Department of Planning and Environment

Our ref: DOC23/794273
Your Ref: SSD-45024776

Subject: Response to Submissions – Narwee Parklands Seniors Housing (SSD-45024776)

TPZ and SRZ Distances

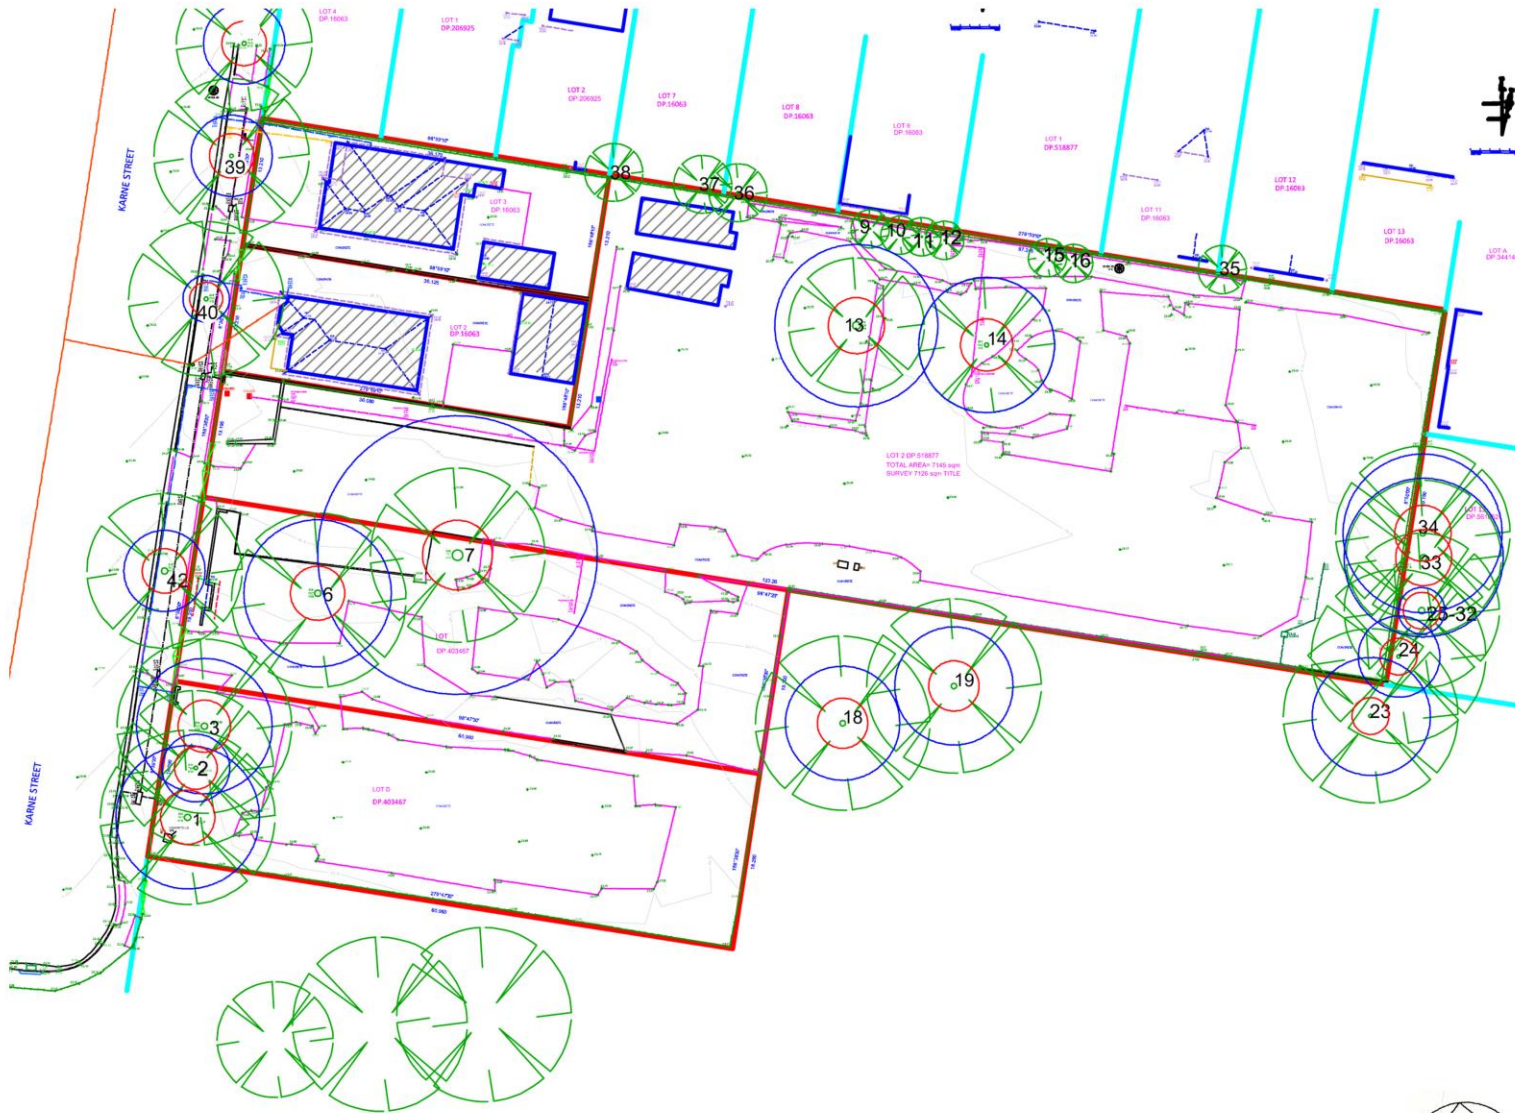
The arborist statement identifies impacts to tree 3 (*Corymbia maculata*) from a proposed substation which cannot be avoided. It is suggested that as the proposed impacts are unavoidable, root mapping can be undertaken post approval. EHG does not support this approach. The proposed impacts to tree 3 have not been quantified and it is unknown if the tree will be removed or retained.

- The impact of the proposed encroachment into the TPZ of tree 3 must be quantified via root mapping. If root mapping demonstrates that the tree can be retained this should be detailed in an addendum to the AIA.
- If root mapping is not undertaken, it should be assumed that tree 3 will need to be removed and a new BDAR waiver request should be sought. Alternatively, the applicant may prepare and submit a BDAR.
- Cumulative encroachment into TPZ of trees 1 and 2 should also be quantified. The AIA previously identified the requirement for hydro excavation within the TPZ of these trees for the installation of stormwater services. The bulk earthworks plan indicates cut within the TPZ of the trees. The impacts of this must also be addressed. The level of encroachment into the TPZ of the trees should be quantified and if necessary root mapping undertaken.
